# CSV ARCHITECTS

August 24, 2022

Re: Application no.: A22-003792 – 78 Rosemount Avenue

In response to your comments dated July 4th, 2022, I am providing the following information:

A300 1:100

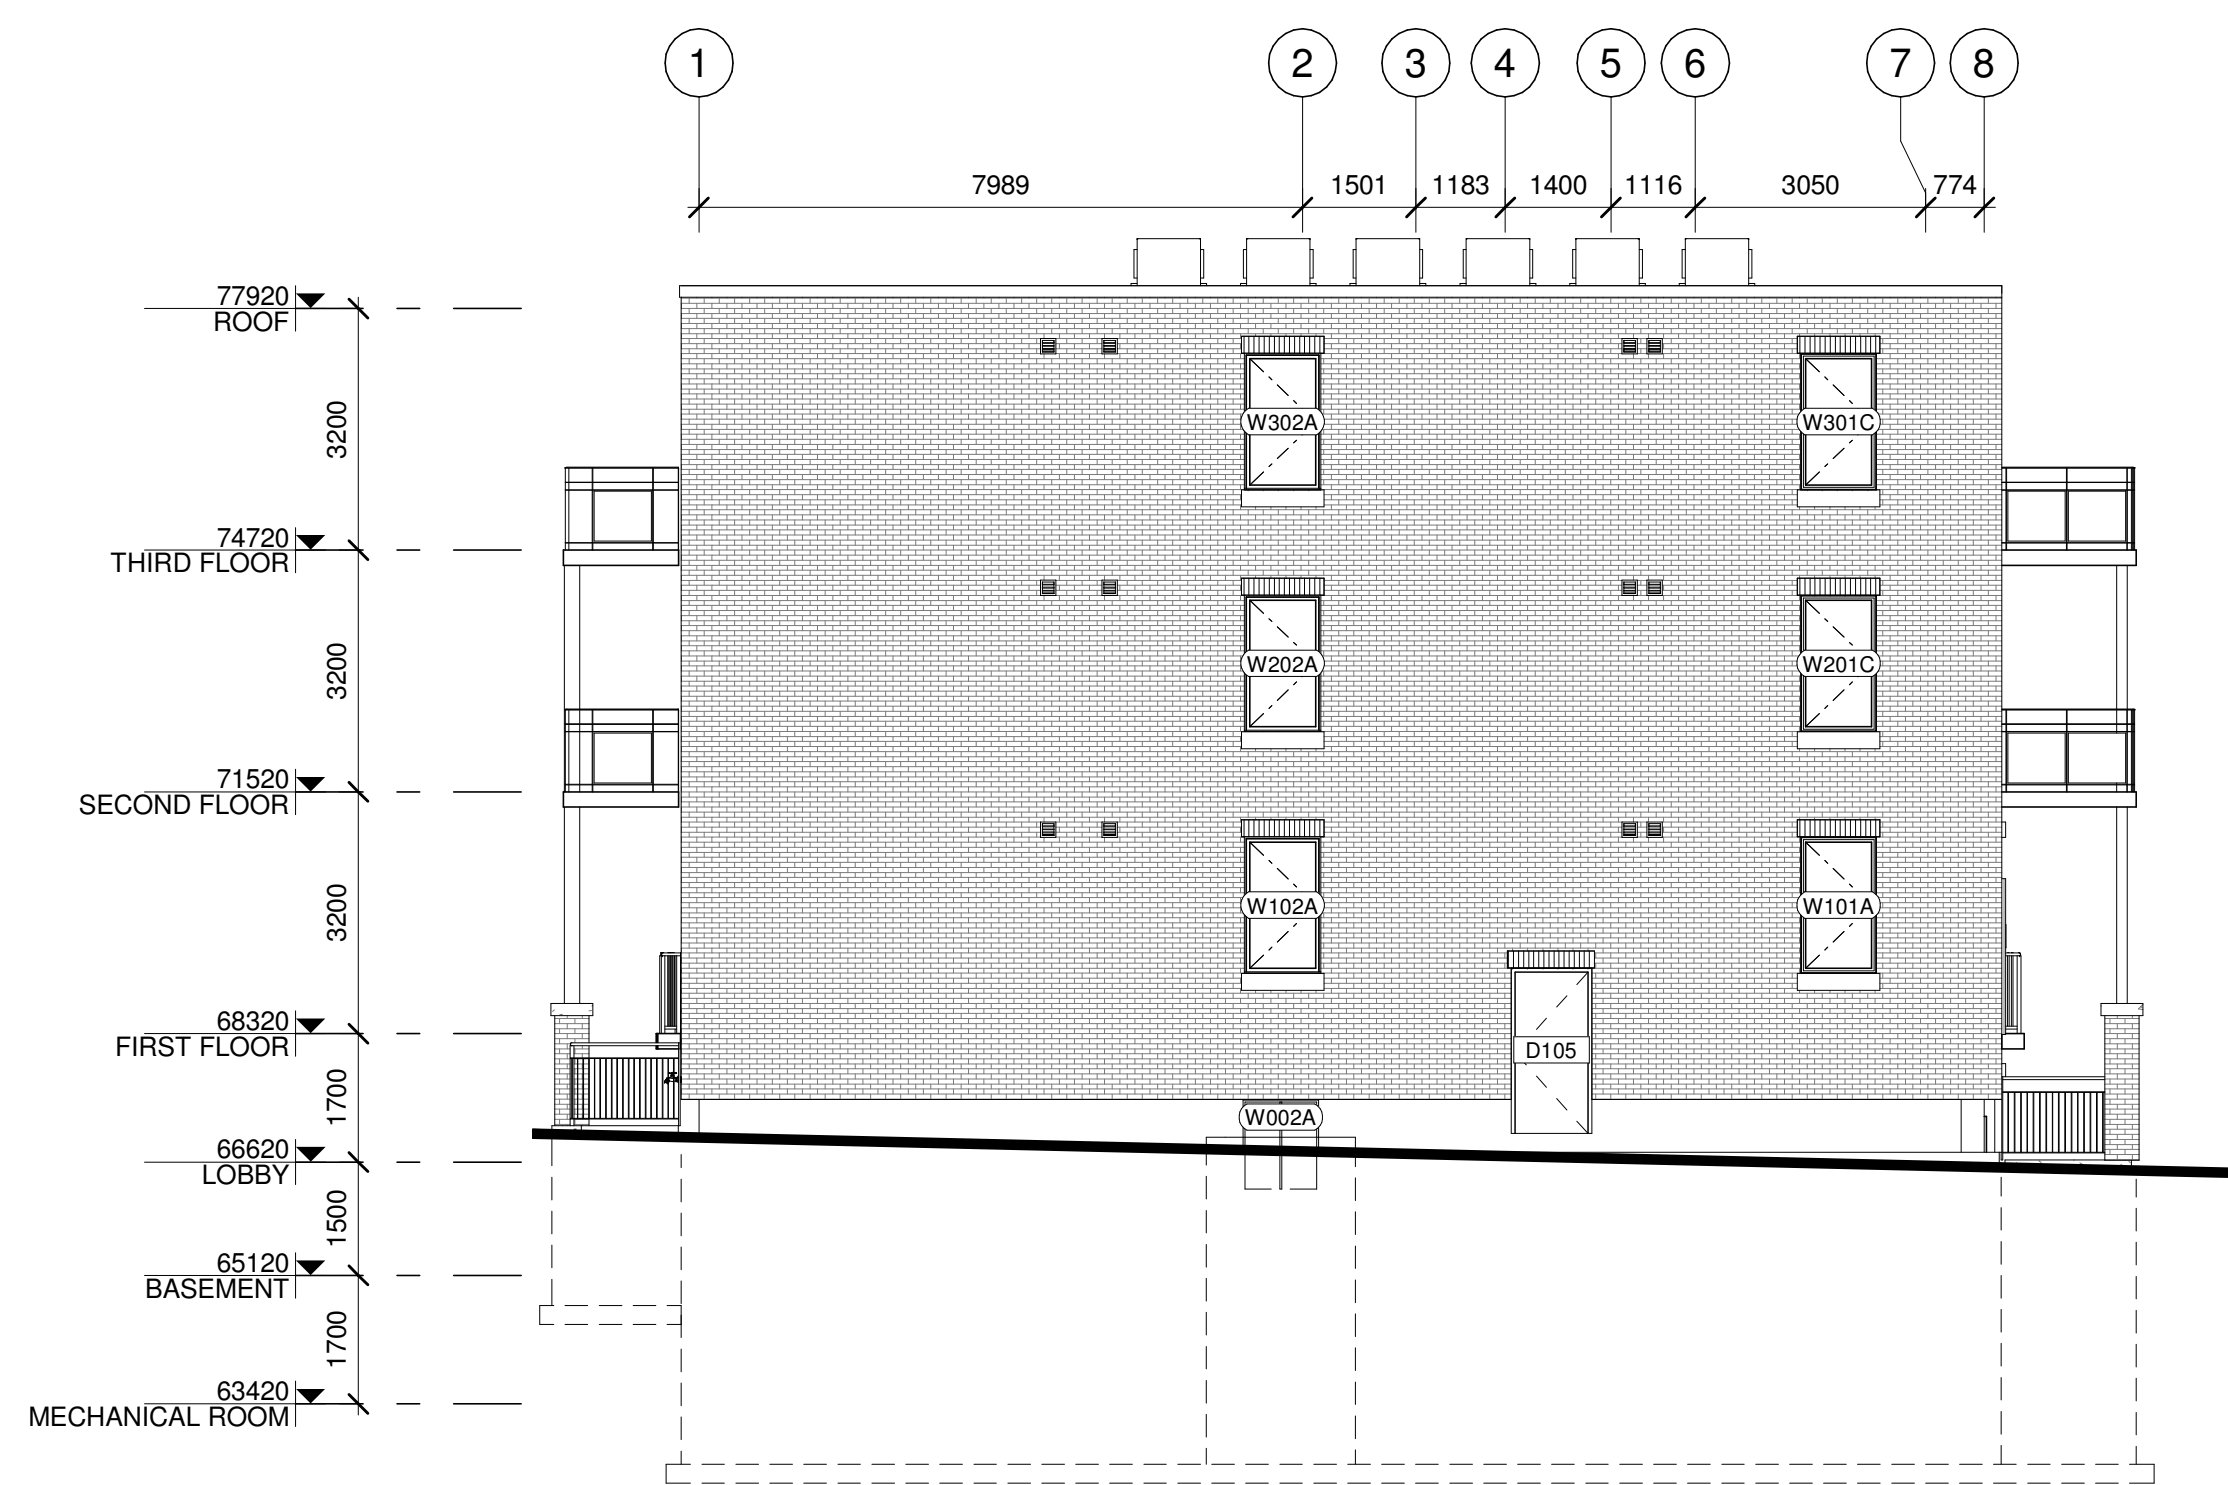
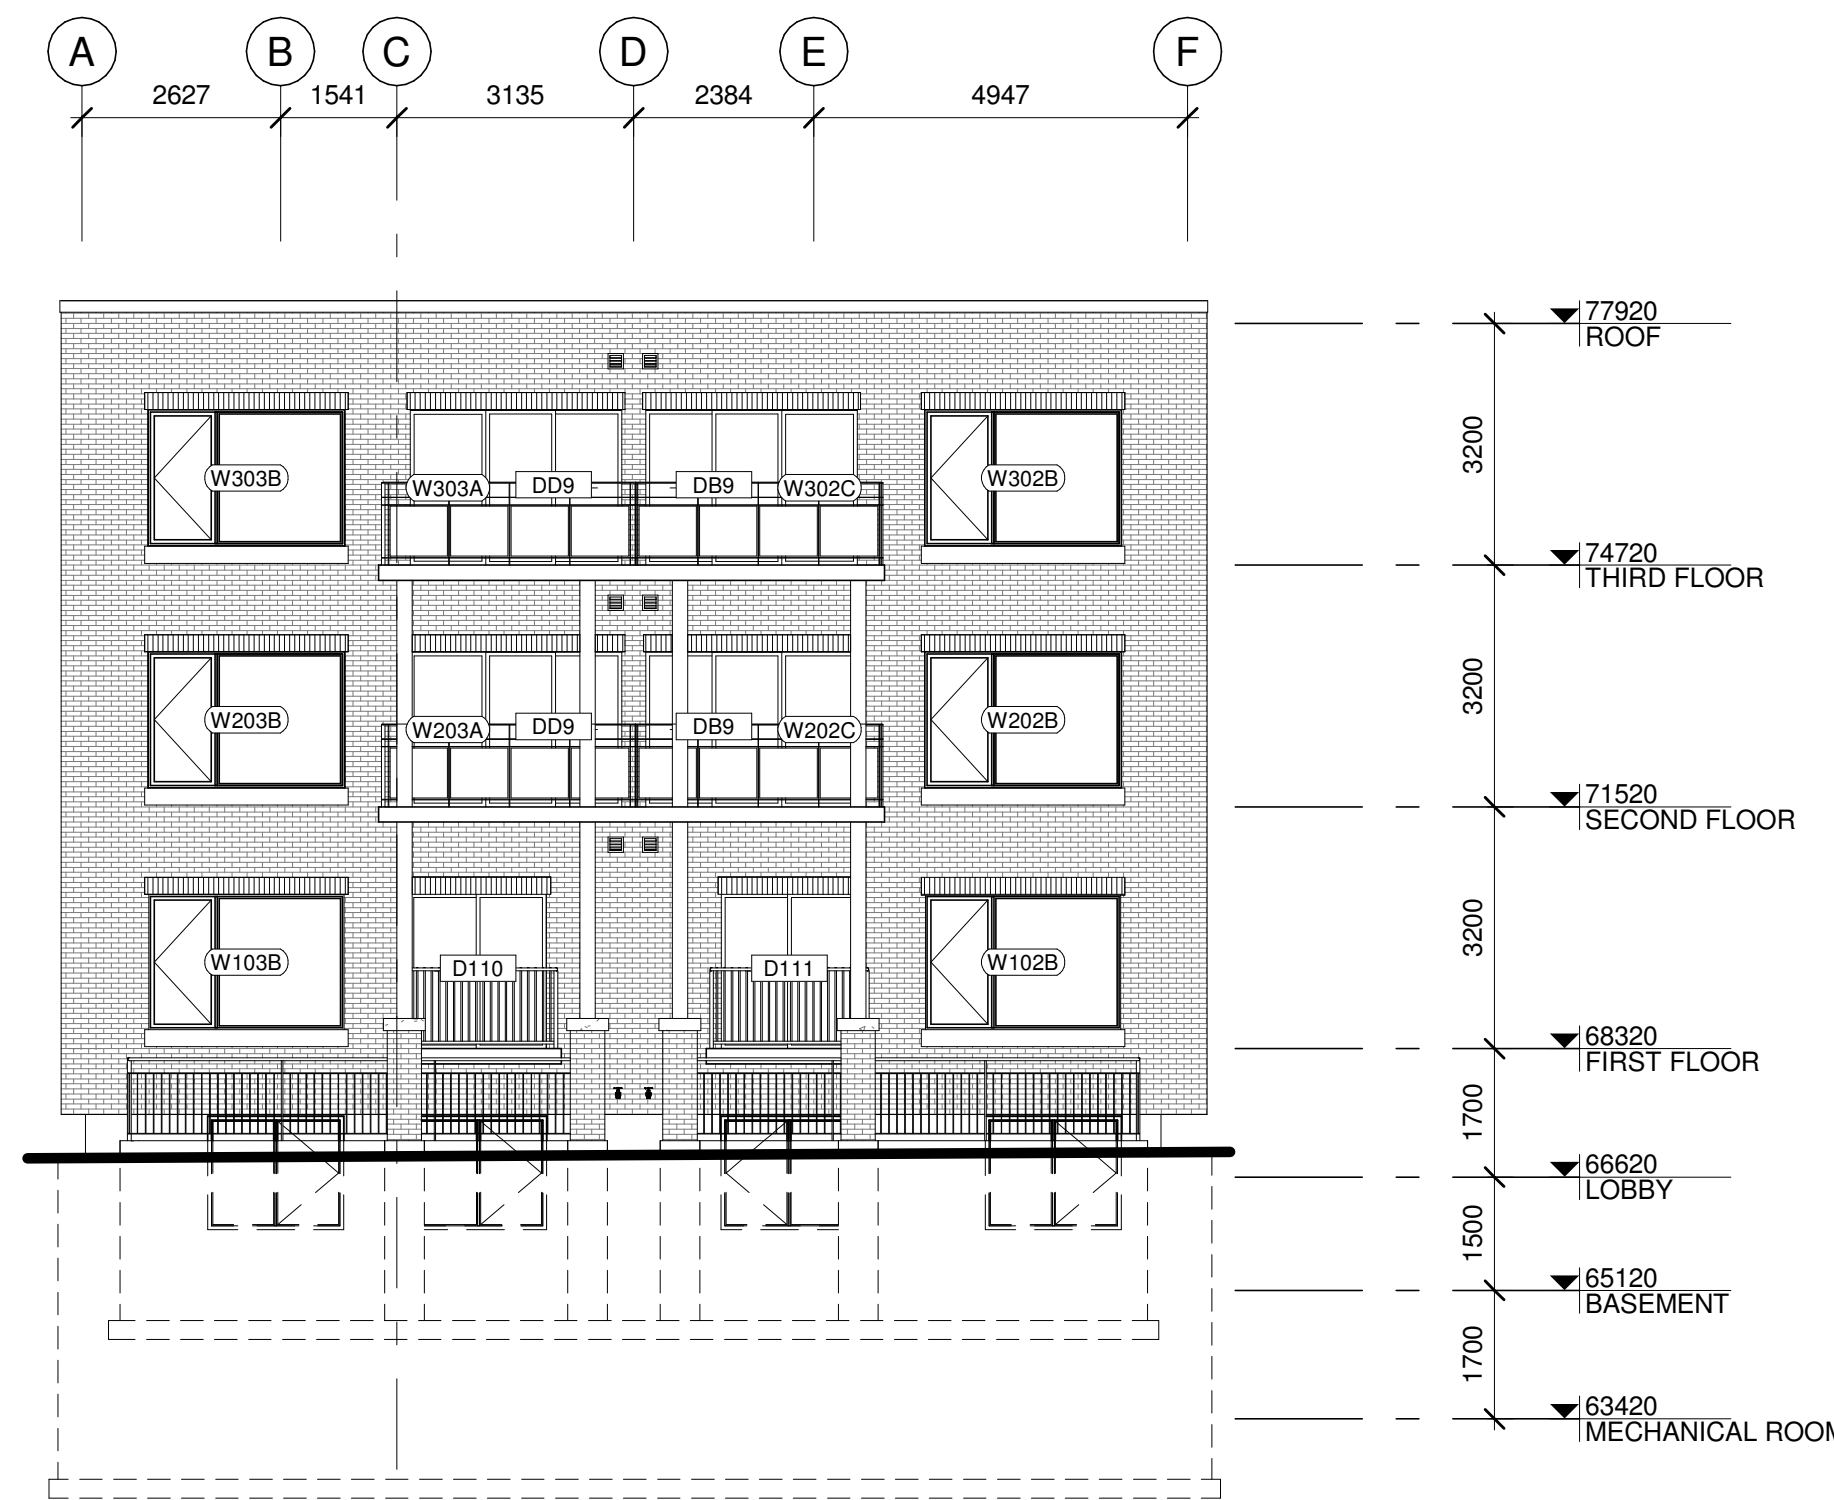
1. The Queensway approval application has been submitted, Aug. 11, 2022, Application Number: 2022-00004071, assigned to Brian Hickey, Ministry of Transportation. See attached.
2. Attached please find the topographic survey. The dimension is taken to the face of the building. There are recesses on the ground floor, however, the majority of the façade is flush at 3.063m. Please see image below:

$66.58 + 66.85 + 66.95 + 66.54 = 266.92 / 4 = 66.73$ . We are adjusting the building height by 19mm to accommodate. Please see the revised elevation drawings for where this mark is located.

4. Please see the revised elevation drawings attached indicating the min. 25% window amount.
